**RE: Aviation Center of Excellence Drainage Report**  
**Engineer's Stamp Date: 2/8/17**  
**Hydrology File: M16D024N**

Based upon the information provided in your submittal received 2/8/17, the Drainage Report is not approved for Grading Permit. The following comments need to be addressed for approval of the above referenced project:

TYPICAL POND DETAIL (I)
SCALE: 1"=5'

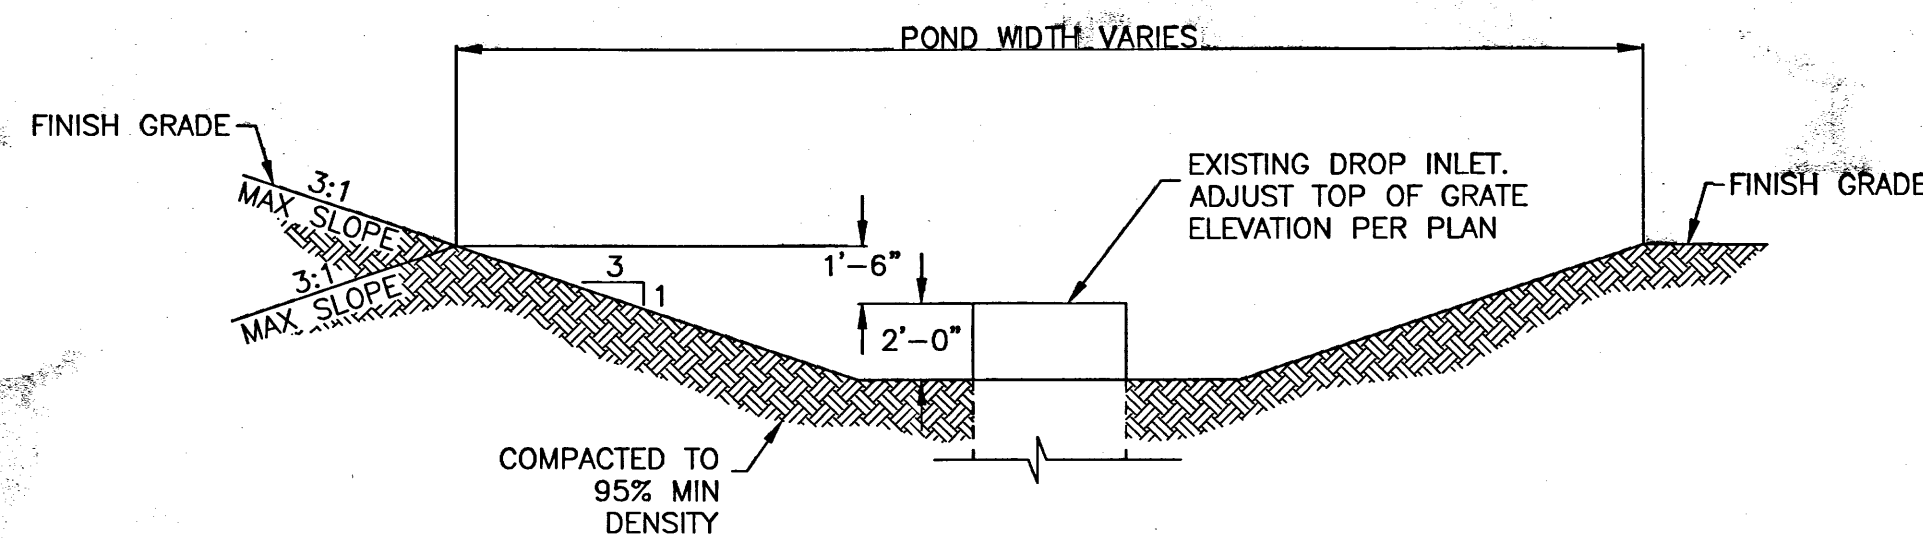
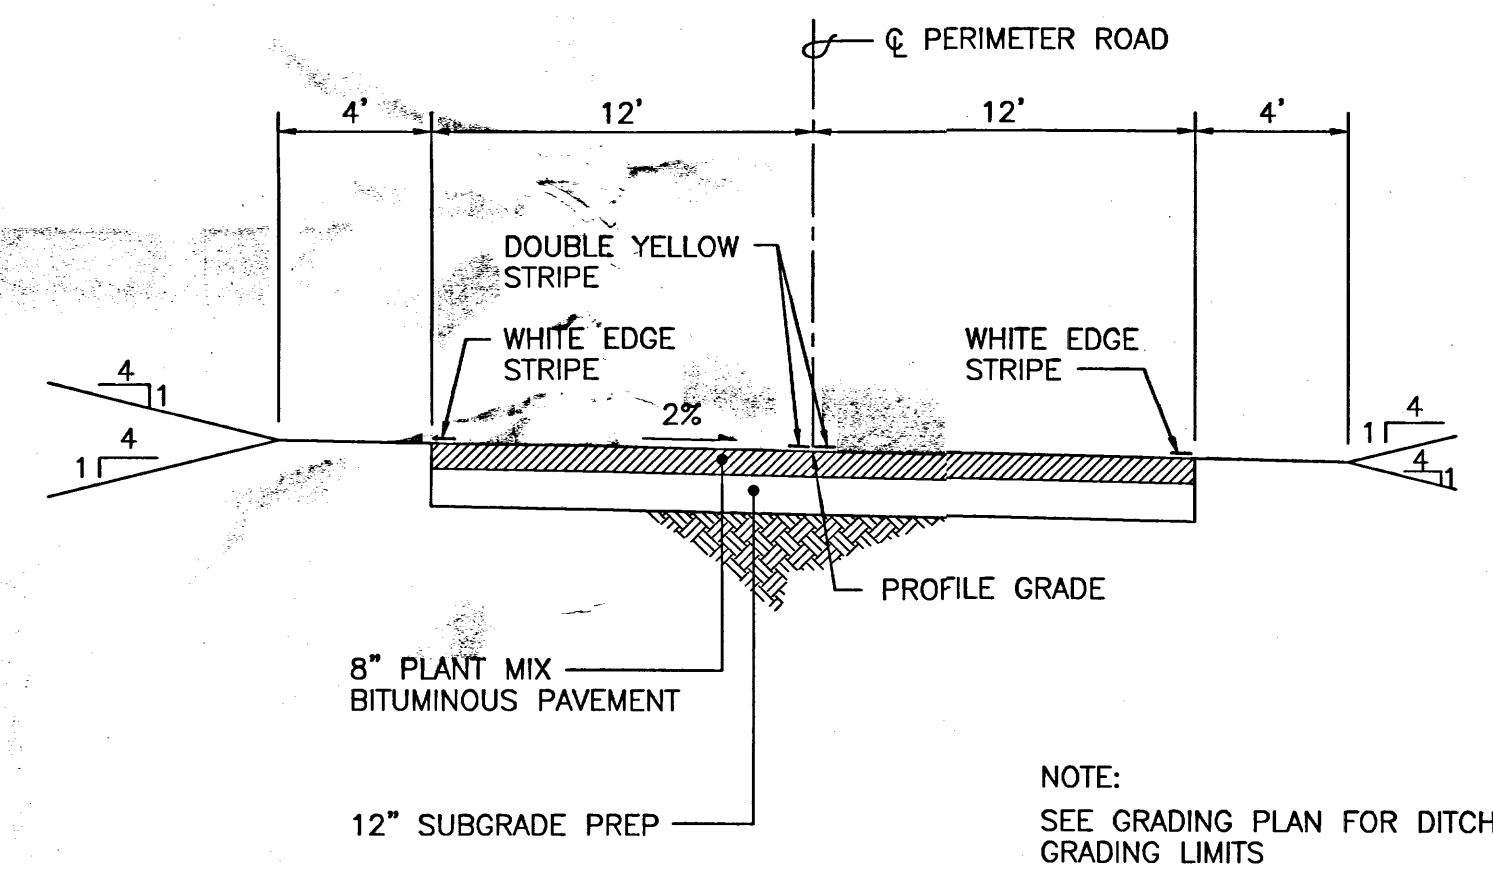
1. The first flush ponds need to be designed as part of these improvements. This information includes pond dimensions, bottom of pond, side slopes, maximum water surface elevation, and pond volume.
2. Waterblocks are necessary where the private roads meet public roads (Girard and Gibson).

It is Hydrology's understanding that these are low-speed, local roads, and the use of dip sections and curb cuts in accordance with standard drawing 2422 is acceptable. If you have any questions, please contact me at 924-3695 or [dpeterson@cabq.gov](mailto:dpeterson@cabq.gov).
